# CHEROKEE METROPOLITAN DISTRICT

## LIFT STATION NO. 1 ADDITIONS

### STORMWATER MANAGEMENT PLAN: PPR-2254

EPC STORMWATER REVIEW COMMENTS  
IN ORANGE BOXES WITH BLACK TEXT

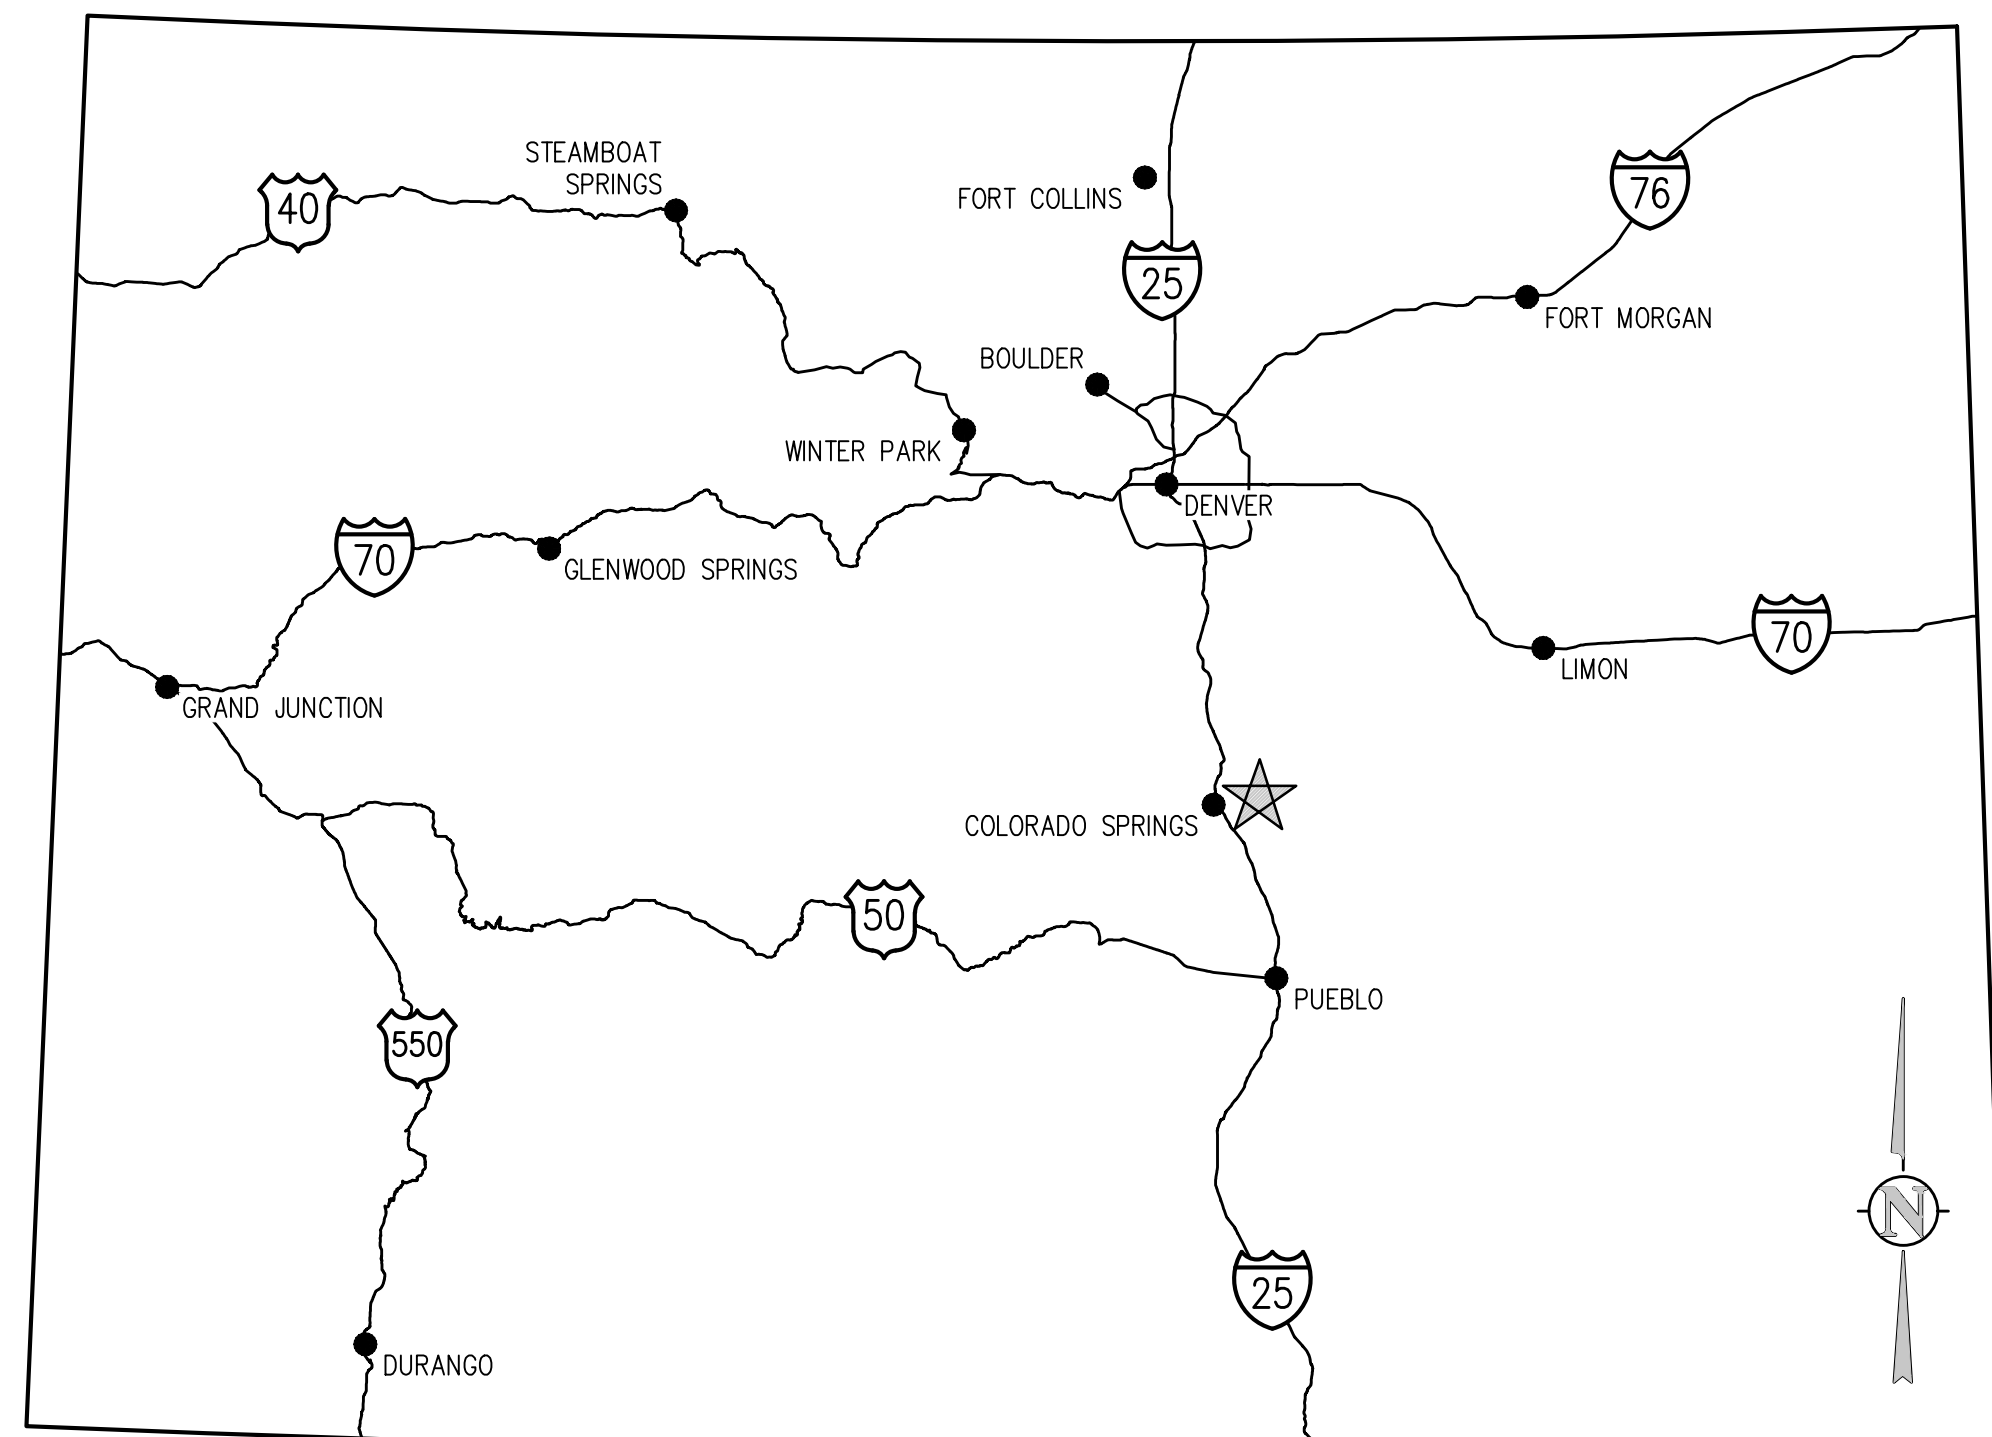
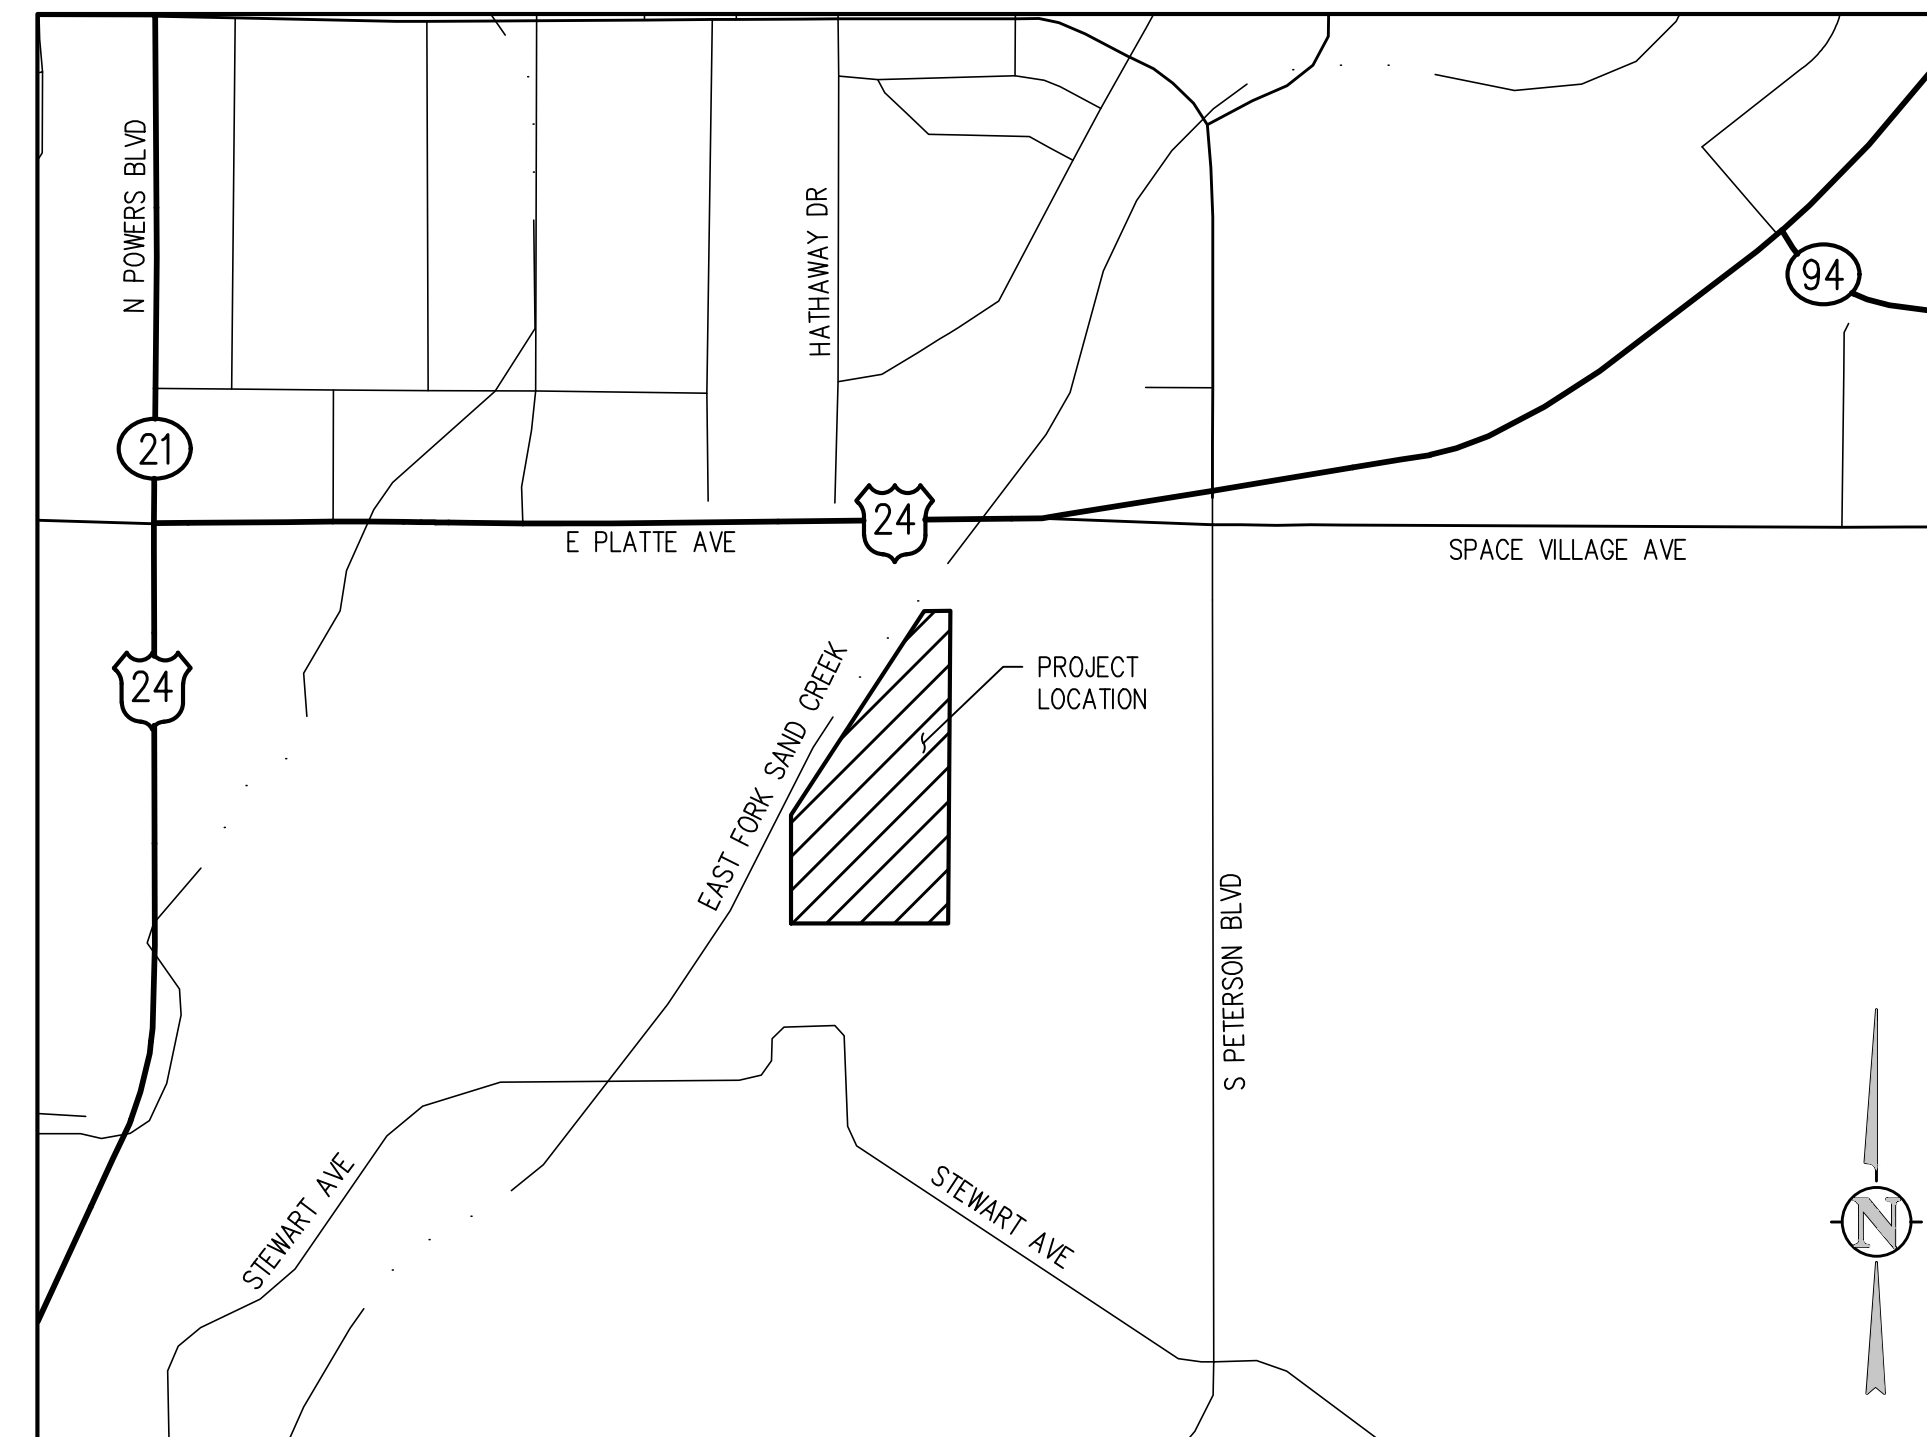
Item 1. Add Qualified Stormwater Manager Information to cover/title sheet. If unknown, add a placeholder to be updated prior to the pre-construction meeting.

Contractor information updated to include Qualified Stormwater Manager Information
